**Ref No:** F2020/00663

Application No: SSD-10831778

**Re: Randwick City Council submission on the State Significant Development SSD-10831778 – Sydney Children’s Hospital Stage 1 and Children’s Comprehensive Campus Centre (SSD-10831778)**

ELEVATION 02 - WEST
1:200

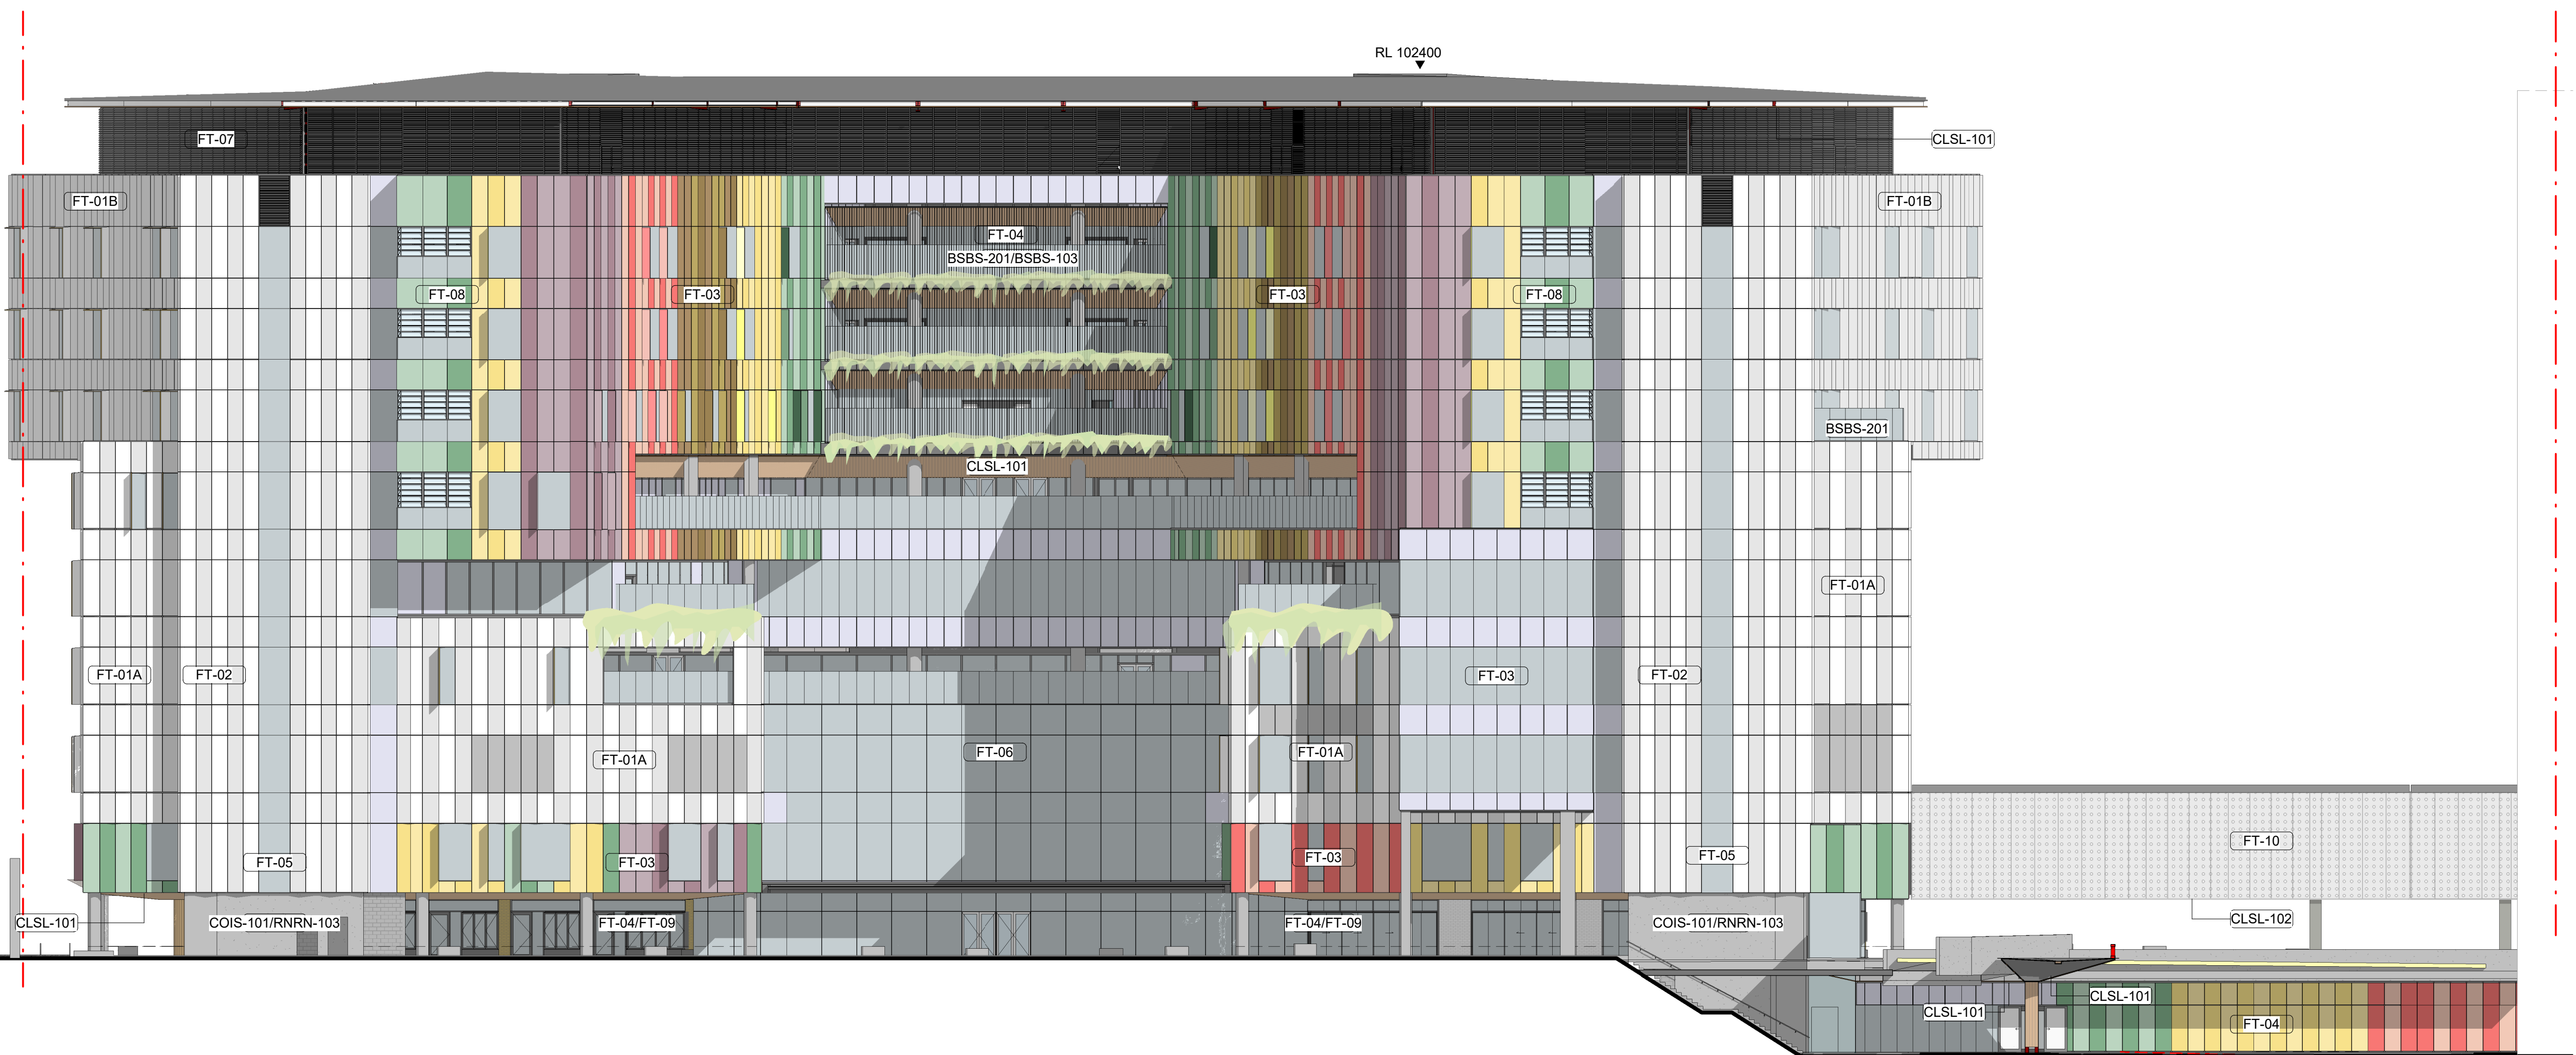
34. The southern Integrated Acute Services Building (IASB) link bridge is two storeys high and crosses over the children's play area. The bridge is low to the ground and is somewhat heavy in appearance. It is recommended that the bridge is redesigned and refined to

maximising the visual openness beneath the bridge and the transparency of the bridge to deliver a thinner profile and fineness of detailing and expression. Rather than repeating the vertical cladding of the main building on the bridge element, a contrasting light steel and glass architectural expression would provide a more successful outcome. A similar approach should be taken for the eastern Children's Hospital link bridge.

35. Council questions the reason for providing a central open-air section with glazed airlocks at each end of the bridge. A continuous glass enclosure may provide better weather protection for people crossing the bridge and remove the need for two airlocks.

1 ELEVATION 03 - NORTH
1:200

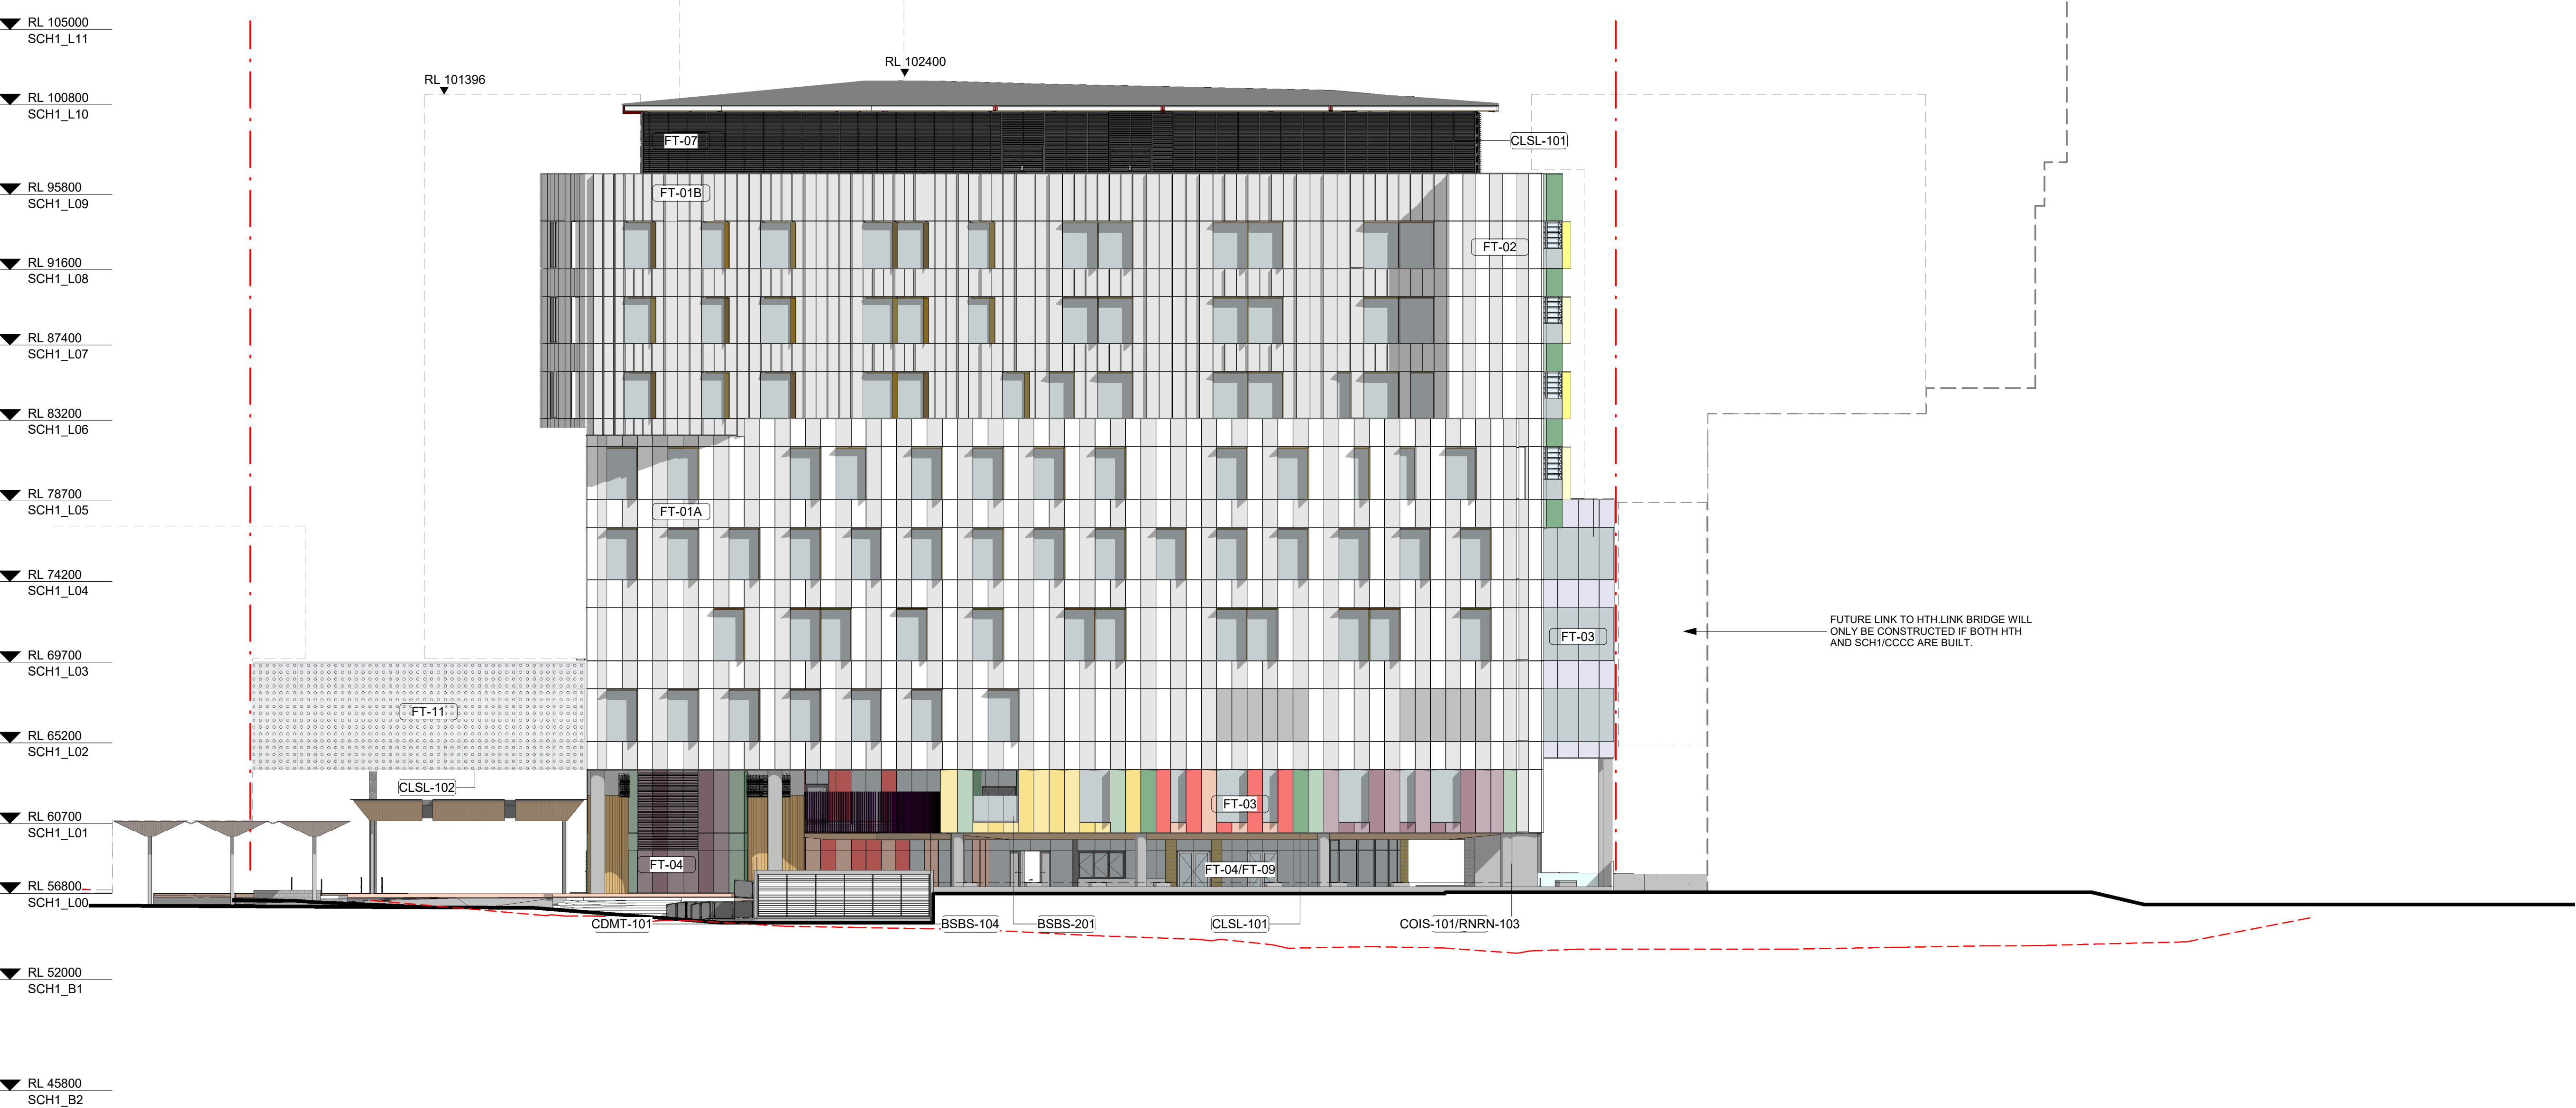
27. The SCH1/CCCC building is expressed as a 6 storey building with 9 storey building setback approximately 8.4m, with level 10 setback a further 3m all around. This generates an interesting dynamic to the High Street frontage within the context of the streetscape. Notwithstanding, the north east overhanging architectural corner requires further development. The submitted perspectives raise concerns regarding the architectural resolution of the overhanging corner element in terms of the expression of the windows, detailing and materiality of this feature. The VIA Photomontage View 2 within the Visual Impact Assessment illustrates the importance and prominence of the northeast corner of the building when viewed west along High Street.

29. The blockish building shaping and white façade panels lacks the warmth and interest of sandstone cliffs. Additional undercroft height and transparency of the ground and first floor levels at the High Street entry would help to create a lighter and more inviting entry experience. The upper level northeast overhanging corner feature is awkward in its current expression and requires further development and refinement.
